From: Michael Flory
Sent: Monday, August 01, 2016 2:54 PM
To: Jeff Watson
Subject: RE: LP-16-00002 Miners Camp

[LP-16-00002 Miners Camp](#) Long Plat

Jeff Stubbs, authorized agent for property owner Miners Camp LLC has submitted a Preliminary Plat application to subdivide approximately 8.26 acres into 24 single-family residential lots and open space tracts.

PRELIMINARY PLAT
 PREPARED FOR
 MINERS CAMP, LLC
 A PORTION OF SECTION 19,
 TOWNSHIP 20 NORTH, RANGE 15 EAST, W.M.
 KITTITAS COUNTY WASHINGTON

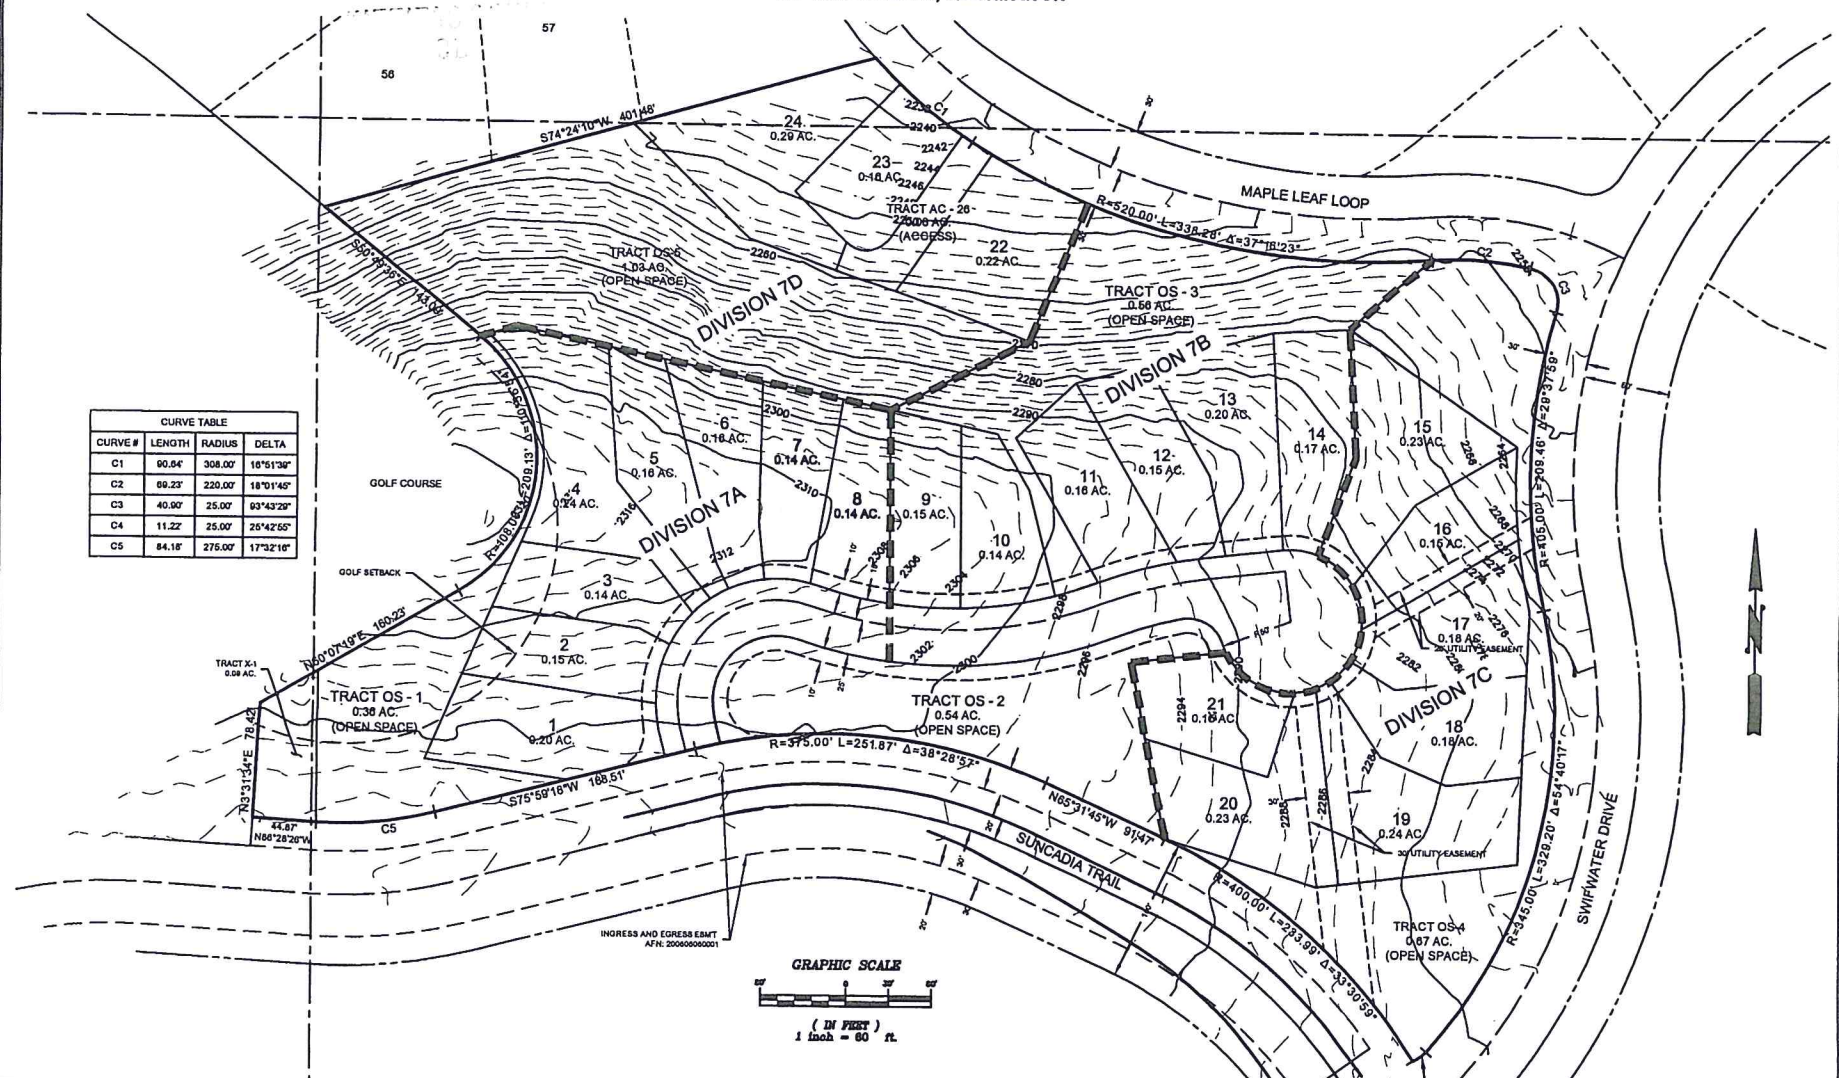
FOLLOW ALL SETBACKS TO STEEP SLOPES PROVIDED BY GEO-TECH. FOLLOW RECOMMENDATIONS FOR COMPACTION & FILL.

PROVIDE FULL ACCESSIBILITY TO ANY AMENITIES ON SITE.

PRIOR TO COP D OF ANY BUILDING, MUST BE FULLY CONNECTED TO ALL UTILITIES.

MAINTAIN FIRE SEPARATION BETWEEN ALL BLDGS THROUGHOUT PHASING.
